## Application for a non-material amendment following a grant of planning permission. Town and Country Planning Act 1990

SINGLE STOREY EXTENSION (MADE A LITTLE WIDER)  
ROOF AMENDED

20/01143/DCH

INCREASE WIDTH OF EXTENSION & REVISE ROOF  
TO ALLOW GLAZING TO REAR ELEVATION

PROPOSED FRONT ELEVATION

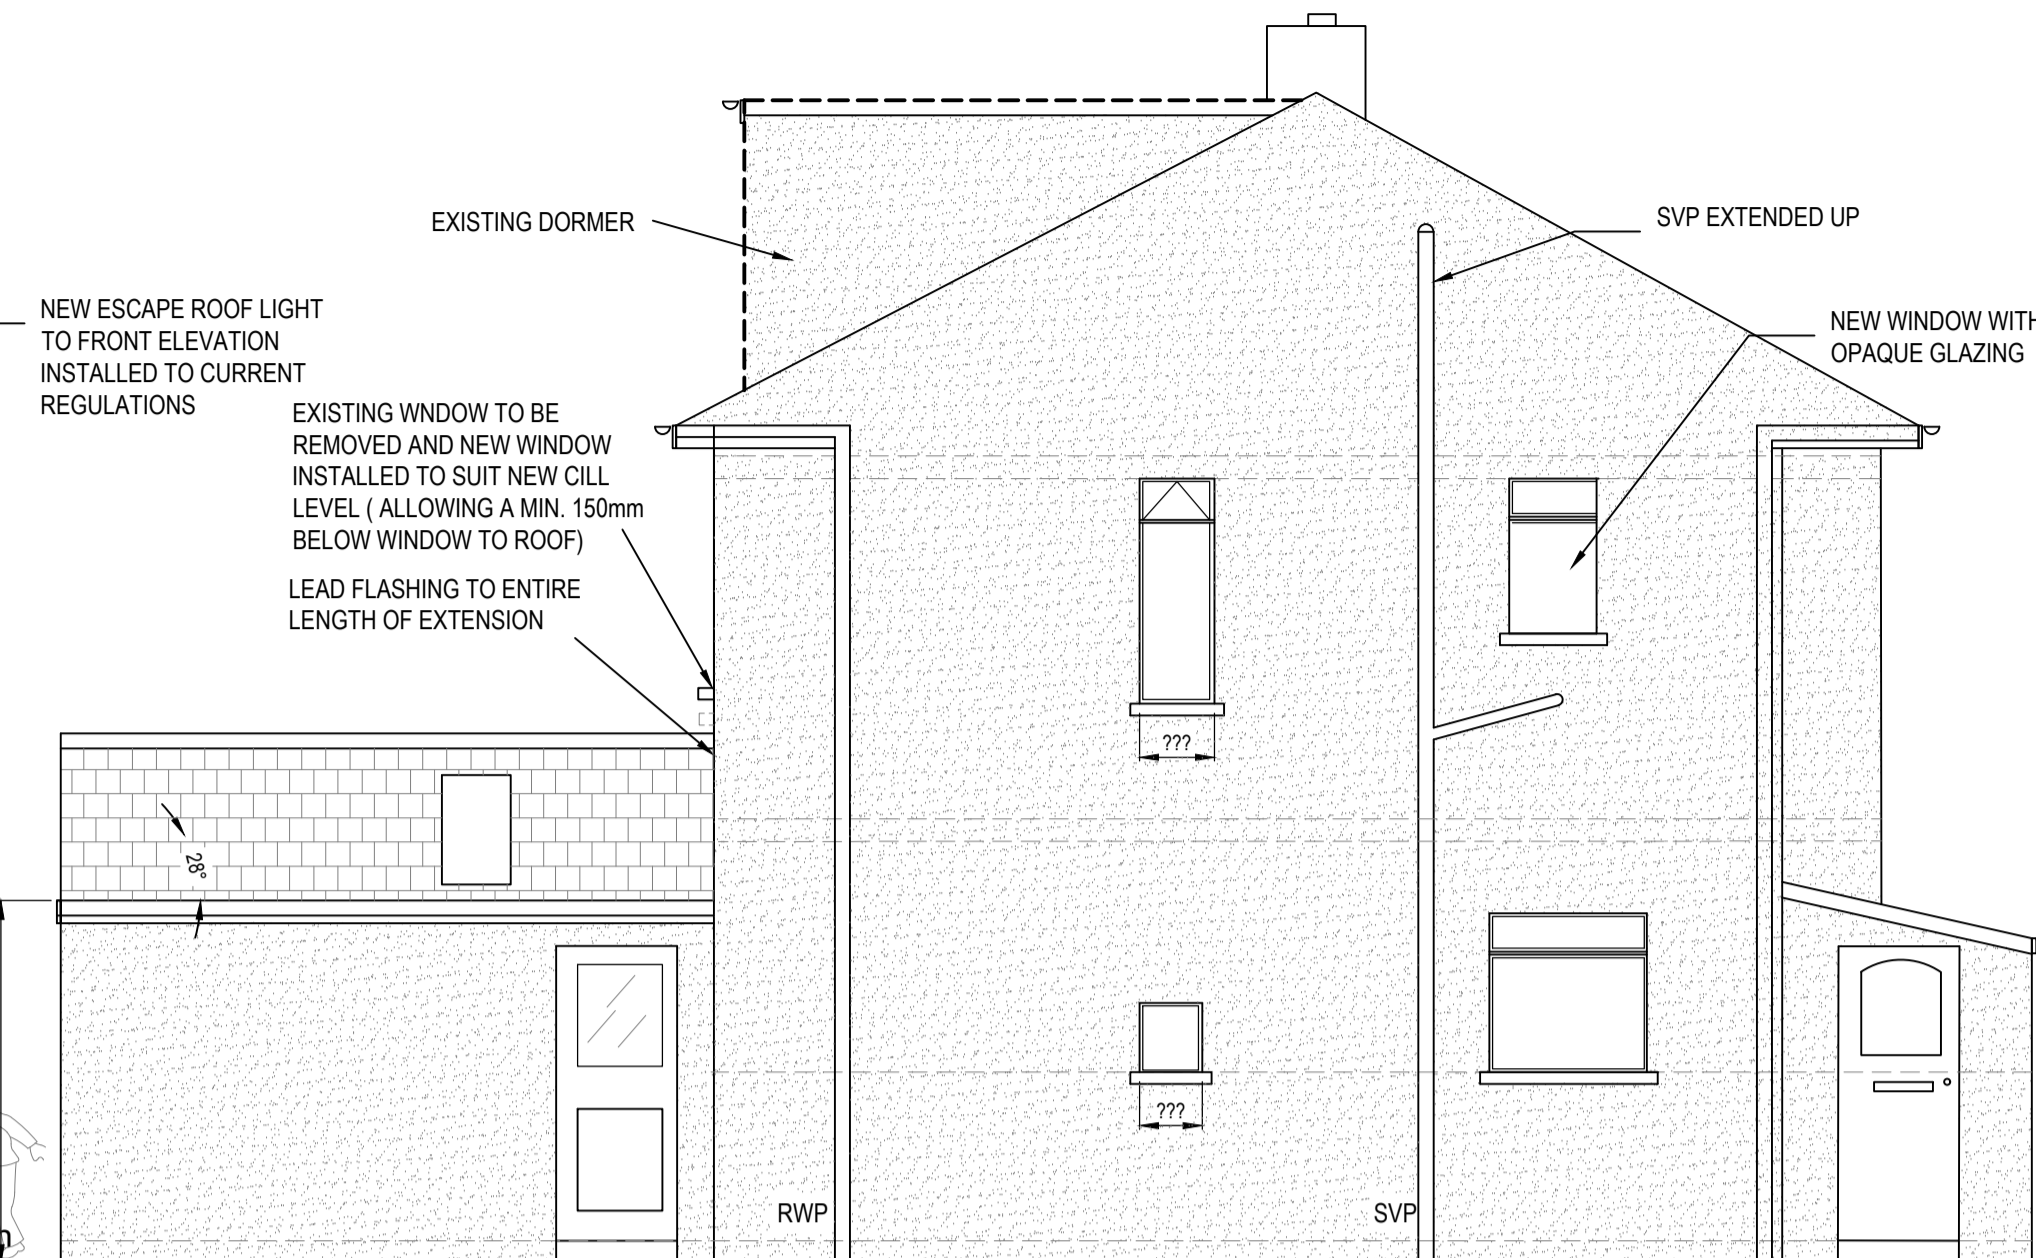
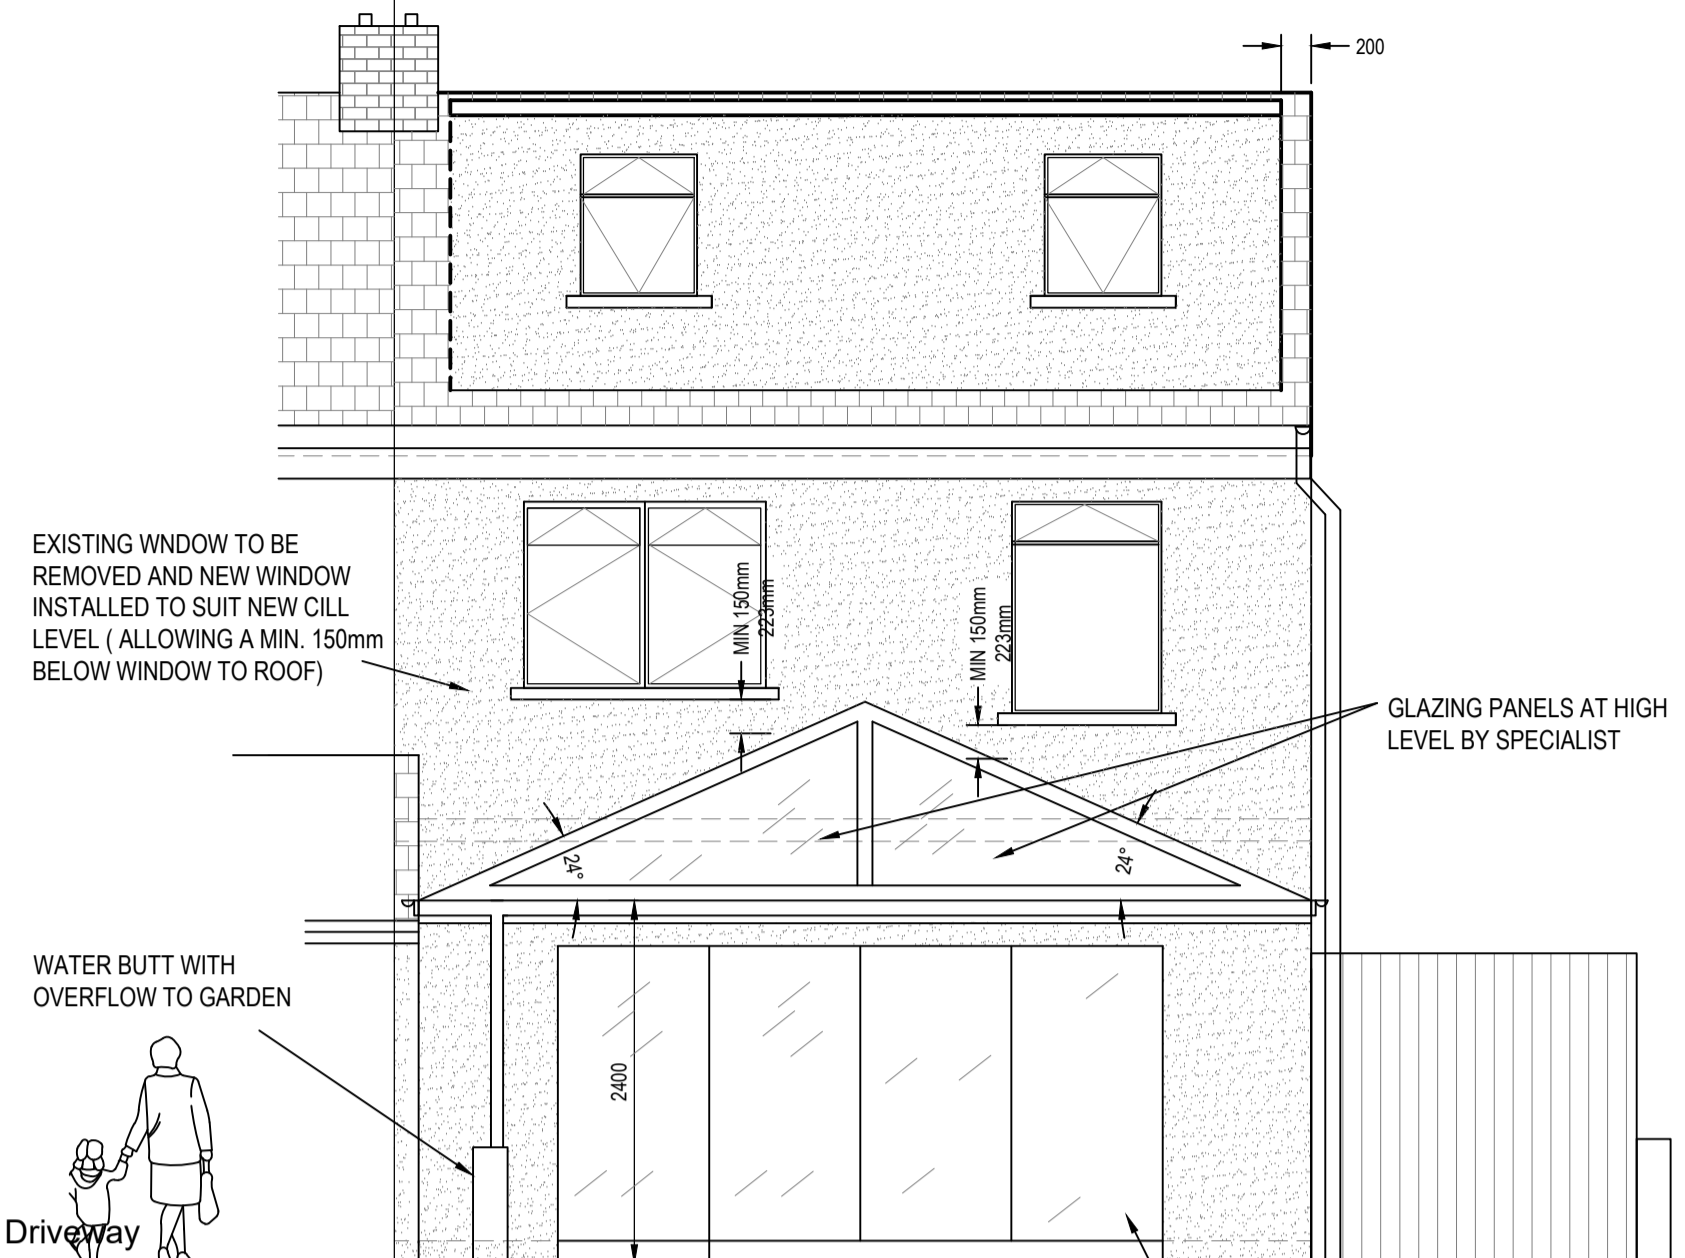
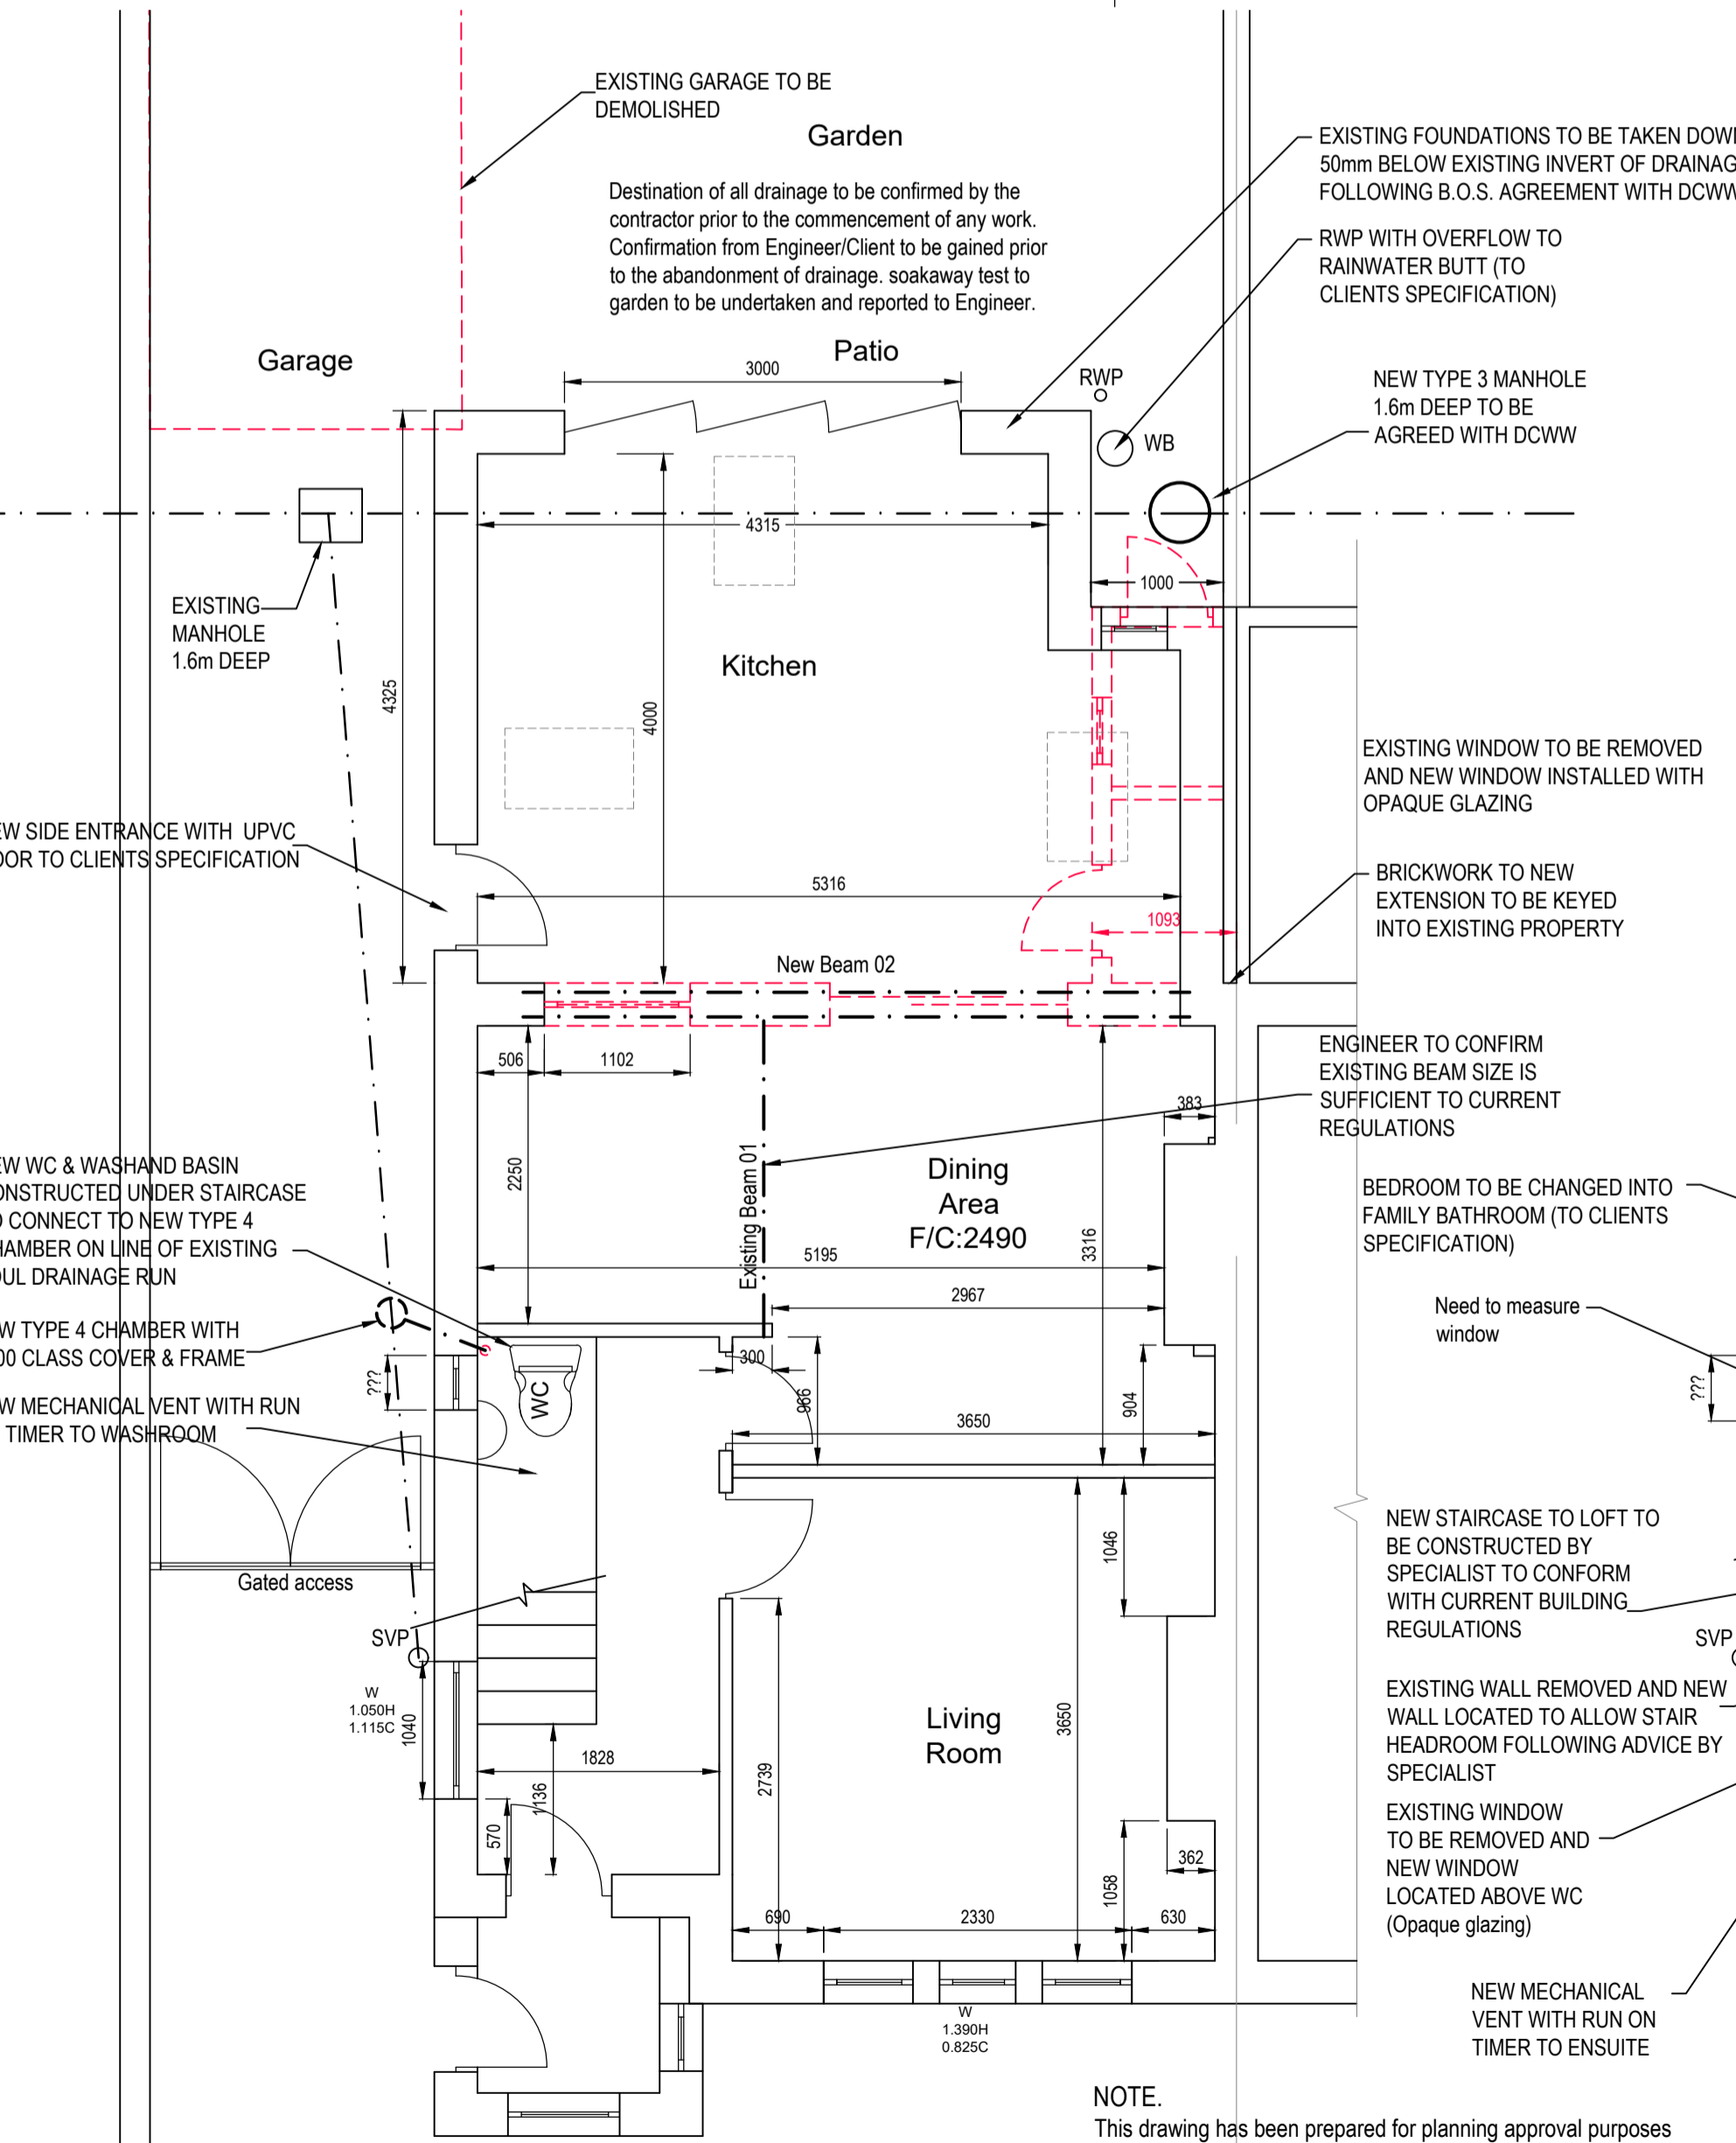
TO ALLOW GLAZING TO TOP OF BIFOLDS @ REAR  
ELEVATION.

C655-ST-PL02-C.
